CLOVERLEAF FILING NO. 2

A REPLAT OF A PORTION OF TRACT B, WOODMOOR PLACER
 LOCATED IN THE NE1/4 OF SECTION 23 AND THE NW1/4 OF SECTION 24, TOWNSHIP 11 SOUTH, RANGE 67 WEST OF THE 6TH P.M.
 COUNTY OF EL PASO, STATE OF COLORADO

JOB NO. 25158.01
 MAY 7, 2021
 SHEET 2 OF 7

DETAIL D

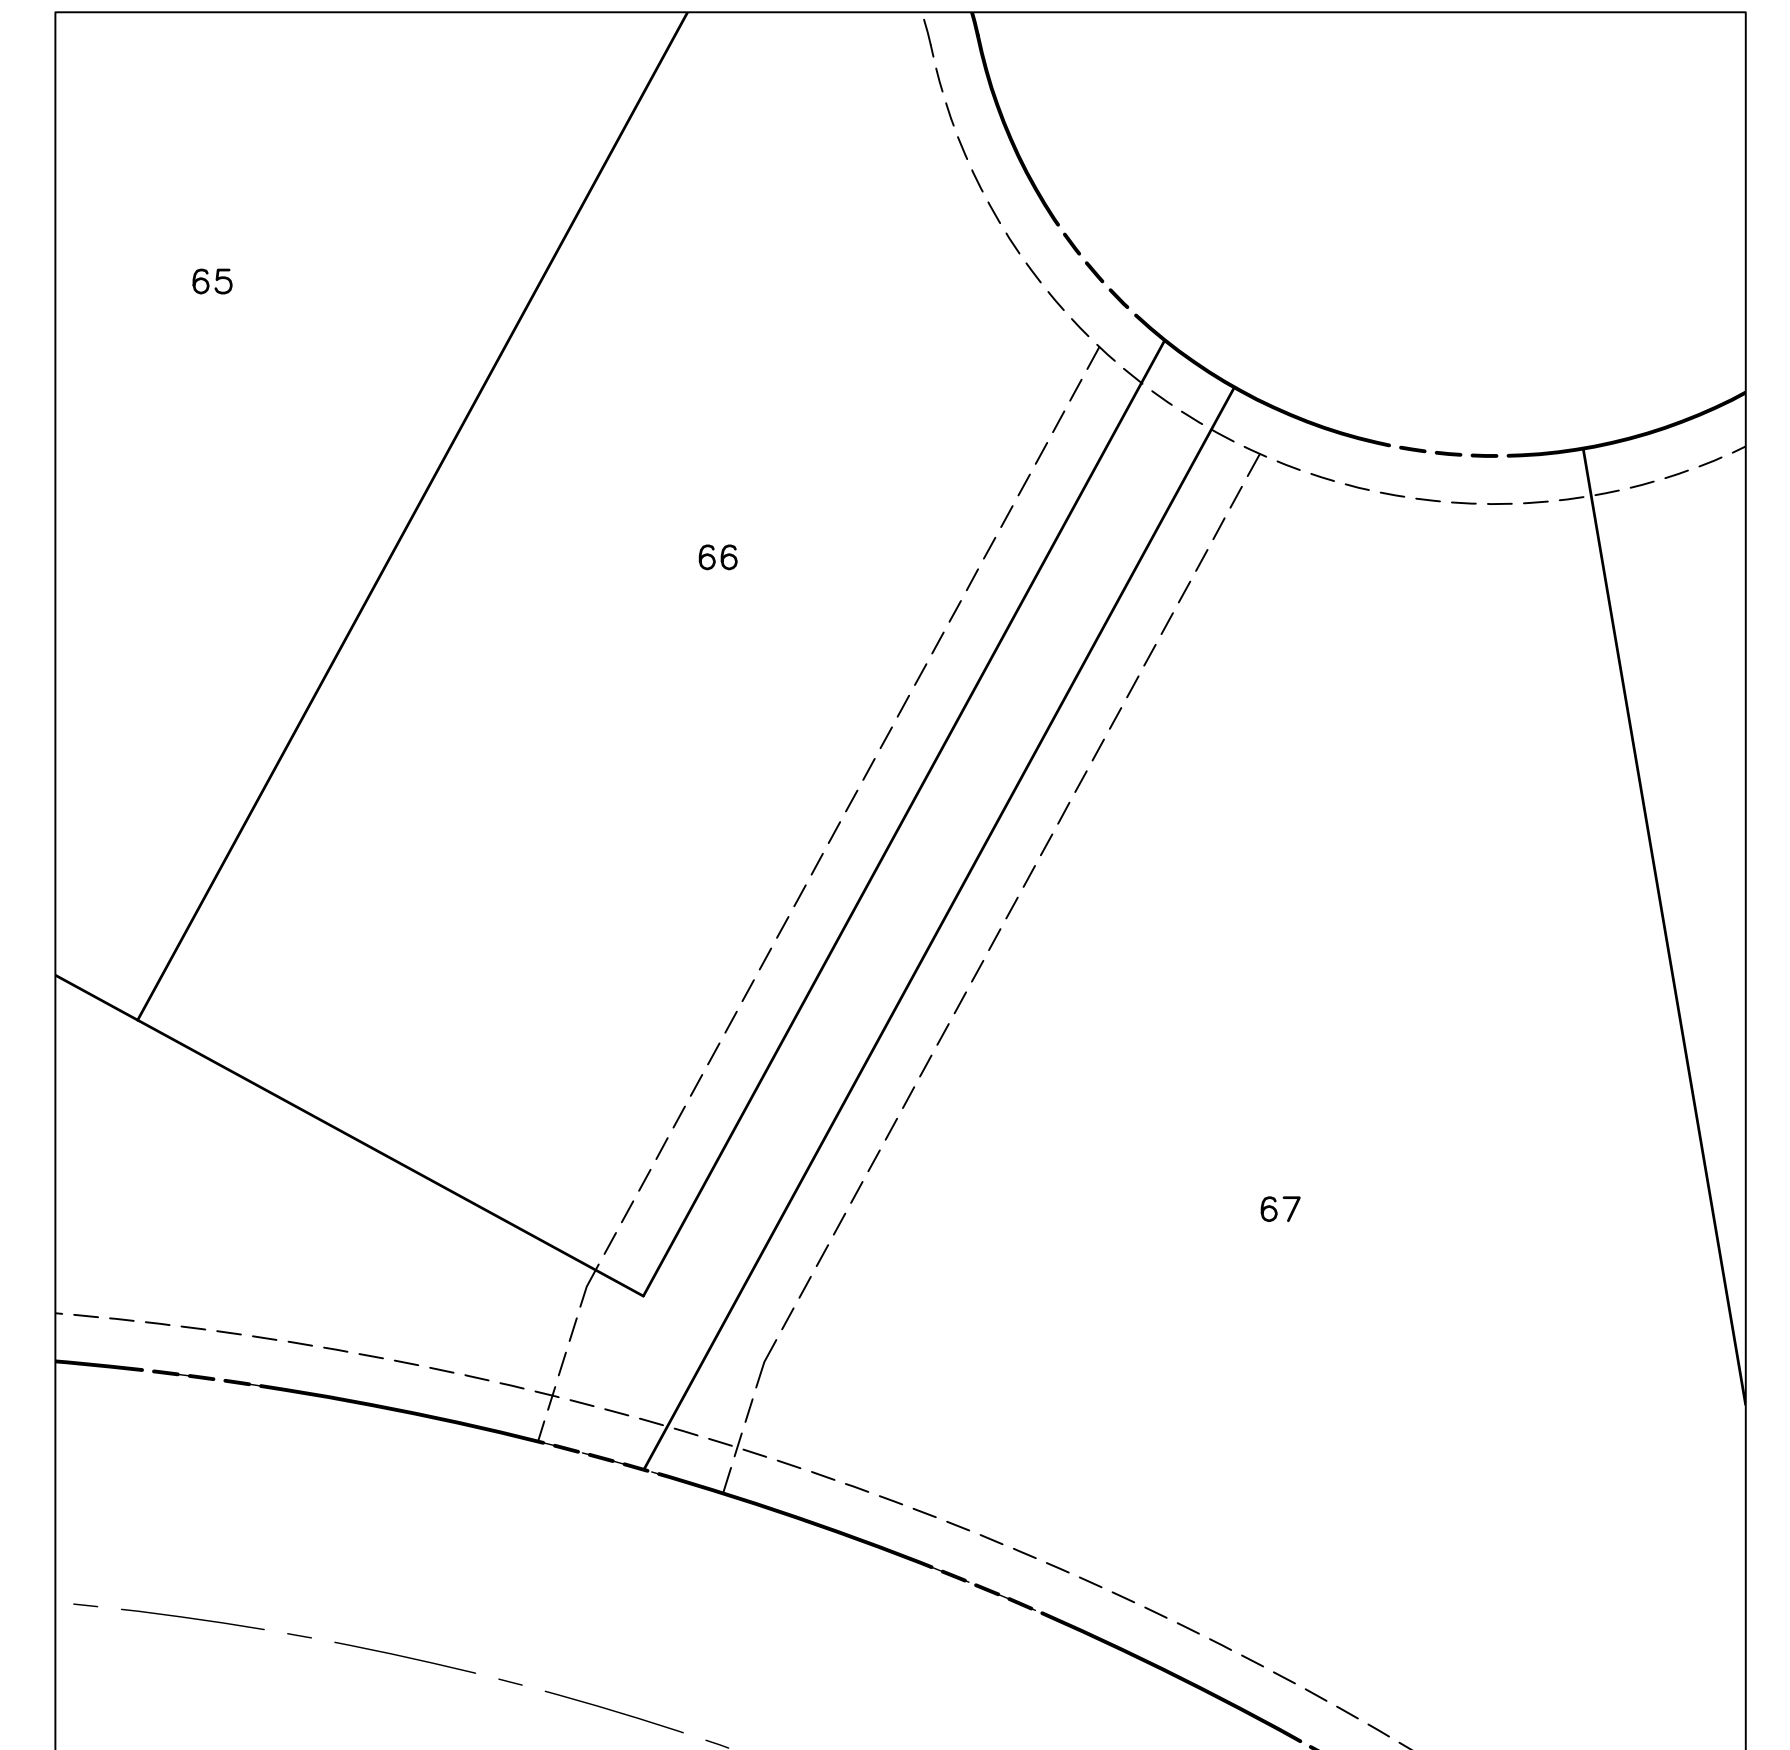
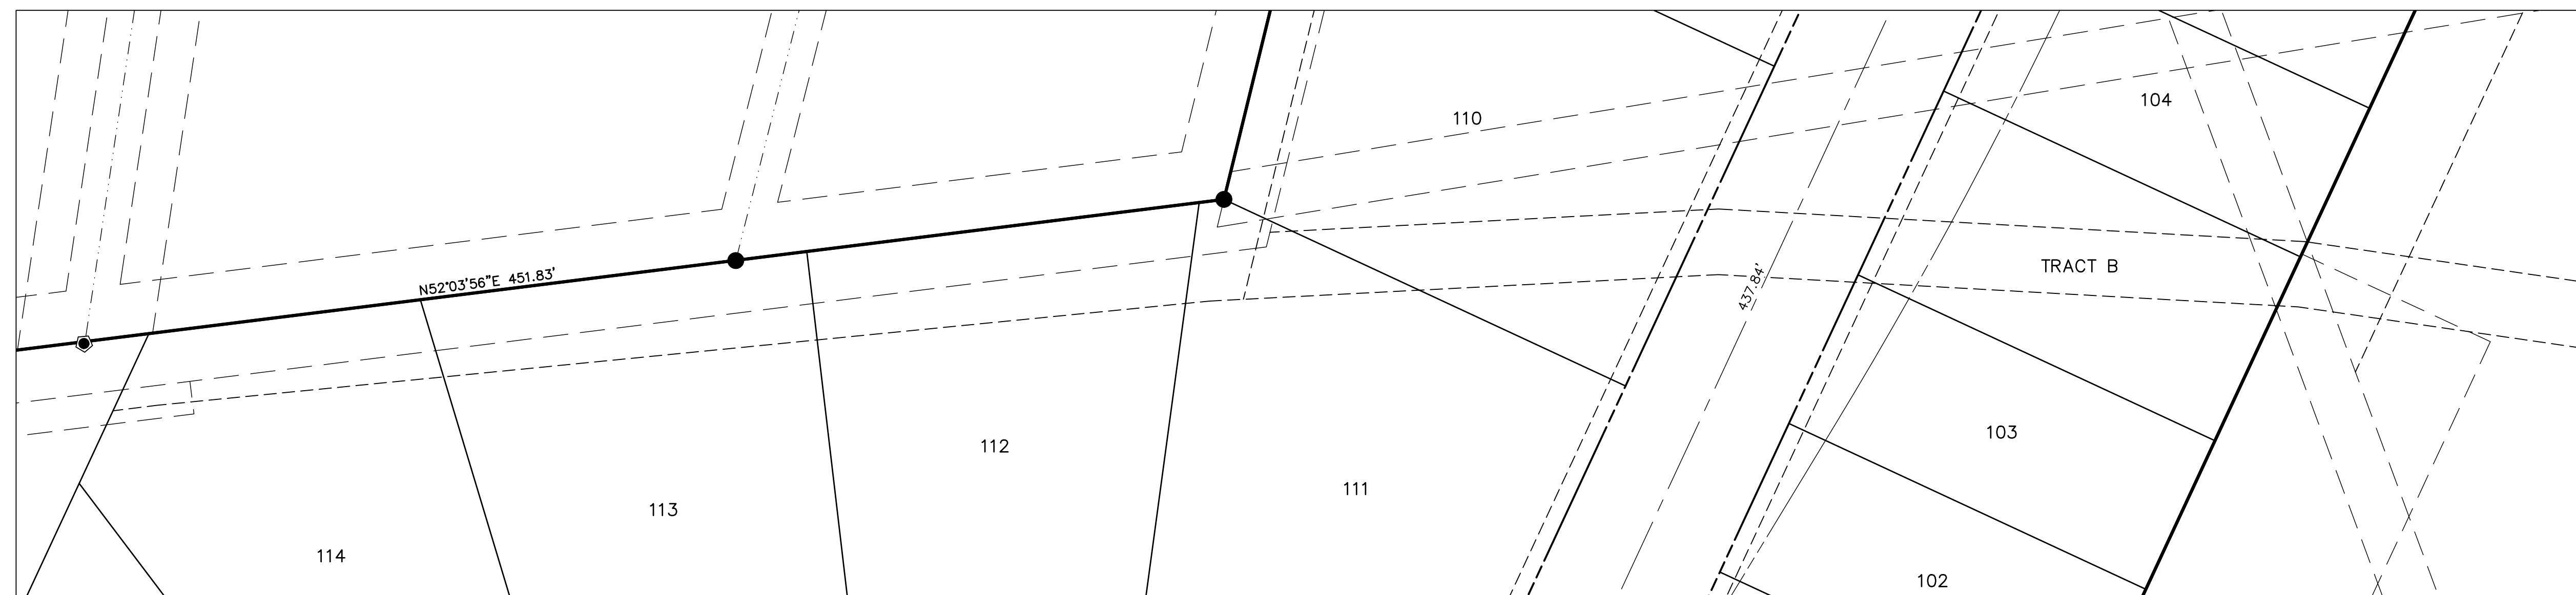
Not sure what the specific information this page is trying to convey.
If it's the easements then provide the bearing/distance information
for the easements
Will be reviewed on the resubmittal

Increase text size
it's legible

Detailing easements Bearing Distances added
